CLOVERLEAF SUBDIVISION

CLOVERLEAF ROAD
EL PASO COUNTY,
COLORADO

REZONE MAP

PCD FILE # P-20-001

1 EXISTING ZONING

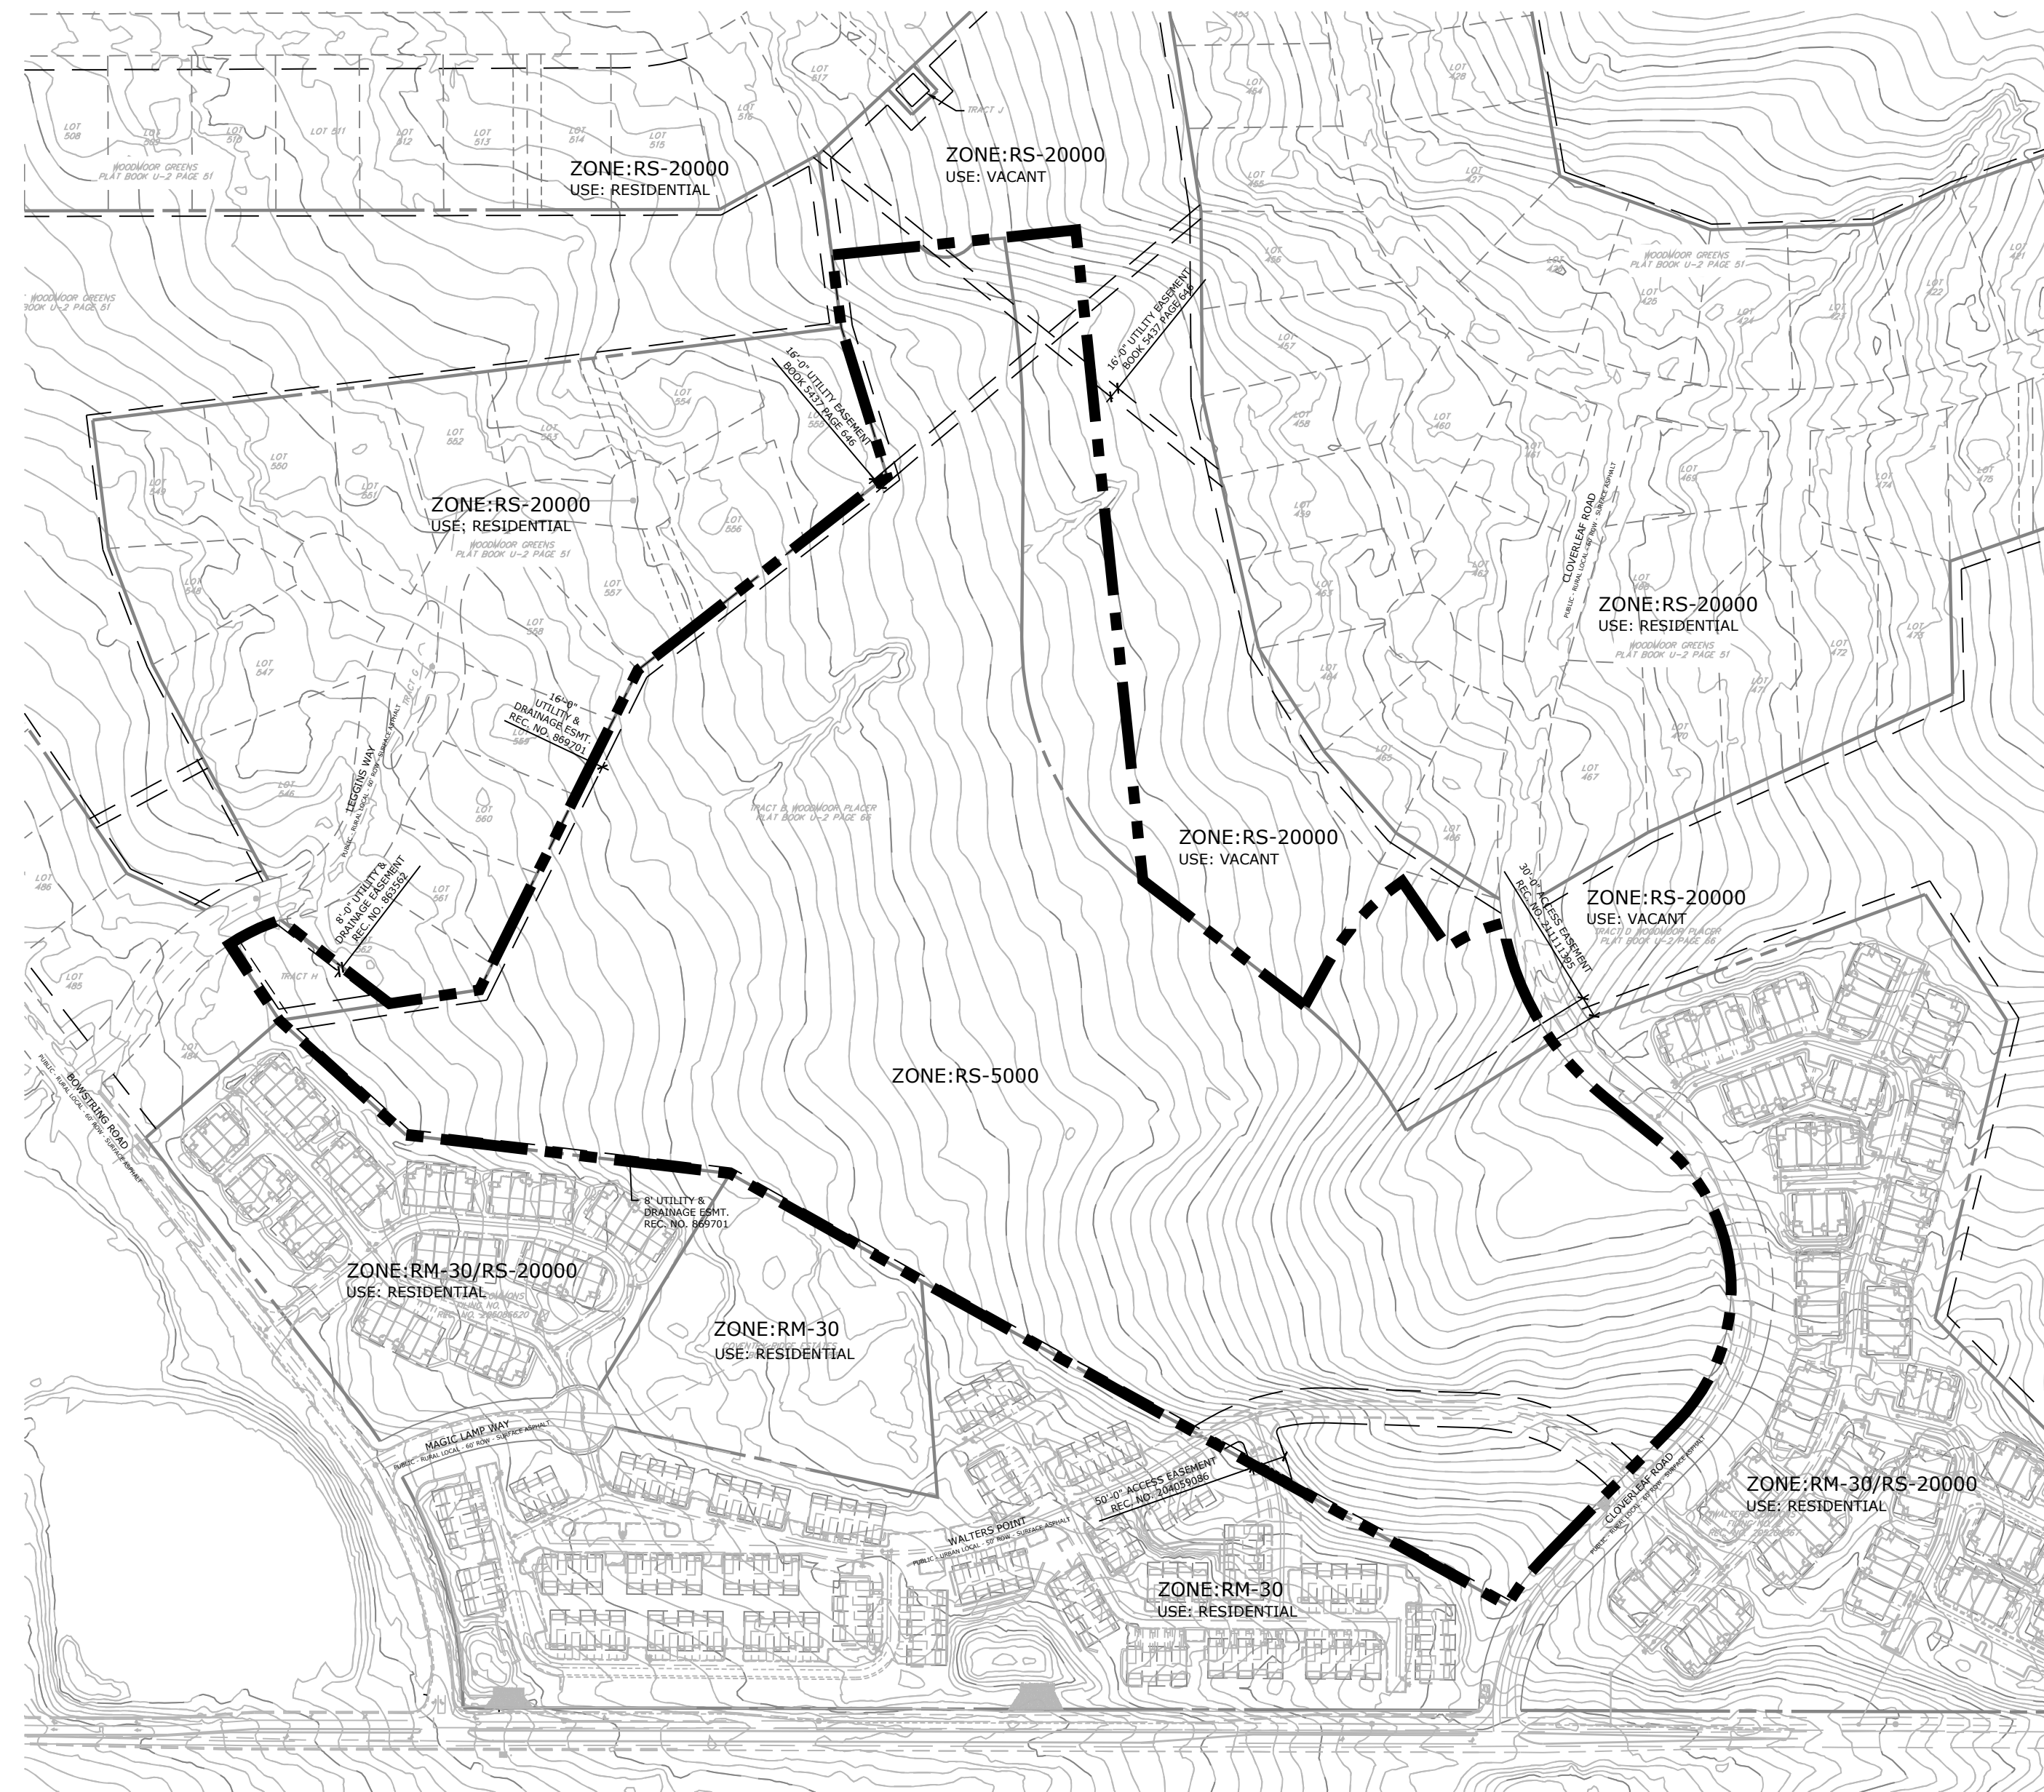
Check this legal description. The assessor's is updated and is different.

Check this legal description. The assessor's is updated and describes it as "Tract H Woodmoor Greens" I checked plat 3756 page 2 and it does appear to reflect this parcel.

Check this legal description. The assessor's is updated and the section number is different.
